Integra 61 - Phase 7 - Non-material Amendment to DM/22/01168/RM

We write on behalf of our client, GMI Construction, in relation to an application for a non-material amendment pursuant to reserved matters permission DM/22/01168/RM relative to Plot DC5 (Phase 7) of planning permission DM/18/01597/VOC. Permission DM/18/01597/VOC relates to Integra 61, land south of Bowburn and west of the A688.

The application proposes a non-material amendment to Condition 1 of the planning permission regarding adherence with the approved plans as set out in Part 3 of the decision notice.

SCALE	DATE	DRAWN	CHK'D
1:500@A1	APR 2022	CW	CW
DRAWING NUMBER	REVISION		
5725.DC5_HSP.2.0	A

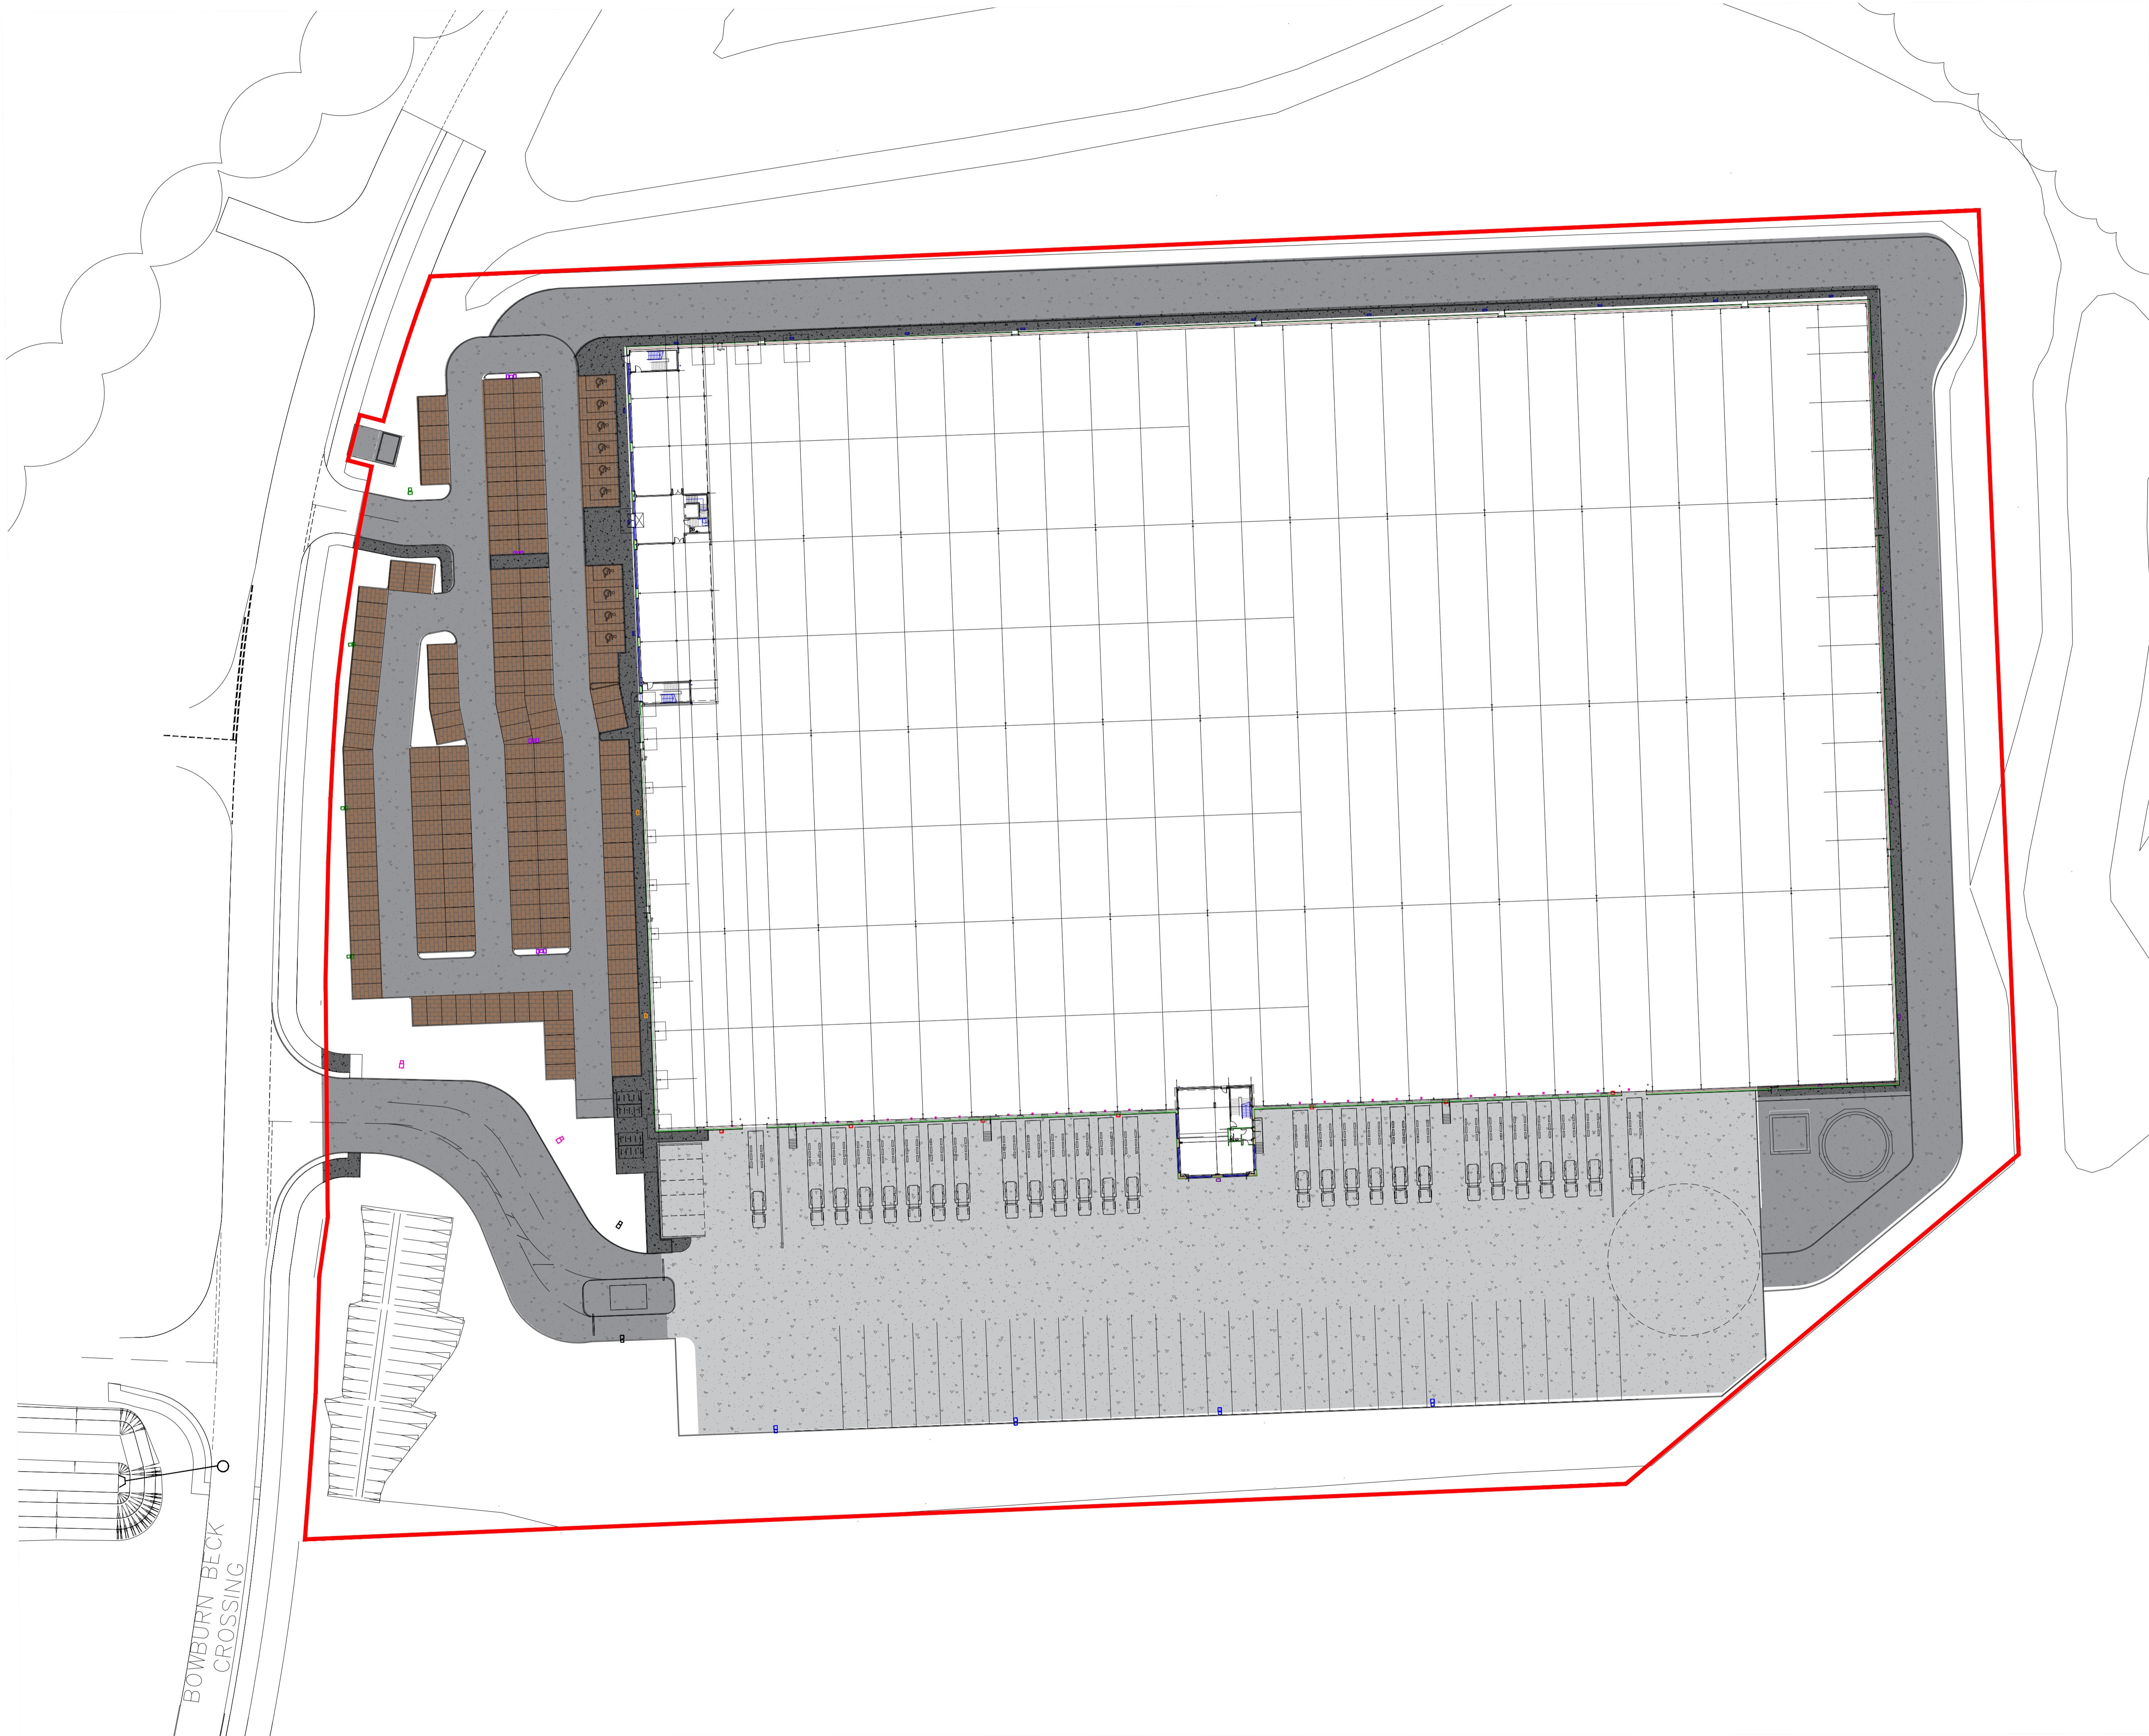
Proposed Site Sections	7069-15-A	7069-15-B	Site levels updated Warehouse F. F. L updated Retaining walls added to drawing
Hard Surface Plan	5725.DC5_HSP.2.0	5725.DC5_HSP.2.OA	Car park layout updated including pedestrian access point Extent of service yard updated local to Georoc retaining wall Width of fire track increased including the corner of fire track extended local to Georoc retaining wall Colour of tarmac footpath updated to black
Planting Plan Overview	5725.DC5_PP.1.0	5725.DC5_CON_PP.1.OA	Updated landscape drawings to capture the general site plan updates
Planting Plan 1 of 5	5725.DC5_PP.1.1	5725.DC5_CON_PP.1.1A	Updated to capture the general site plan updates
Planting Plan 2 of 5	5725.DC5_PP.1.2	5725.DC5_CON_PP.1.2A	Updated to capture the general site plan updates
Planting Plan 3 of 5	5725.DC5_PP.1.3	5725.DC5_CON_PP.1.3A	Updated to capture the general site plan updates
Planting Plan 4 of 5	5725.DC3_PP.1.4	5725.DC5_CON_PP.1.4A	Updated to capture the general site plan updates
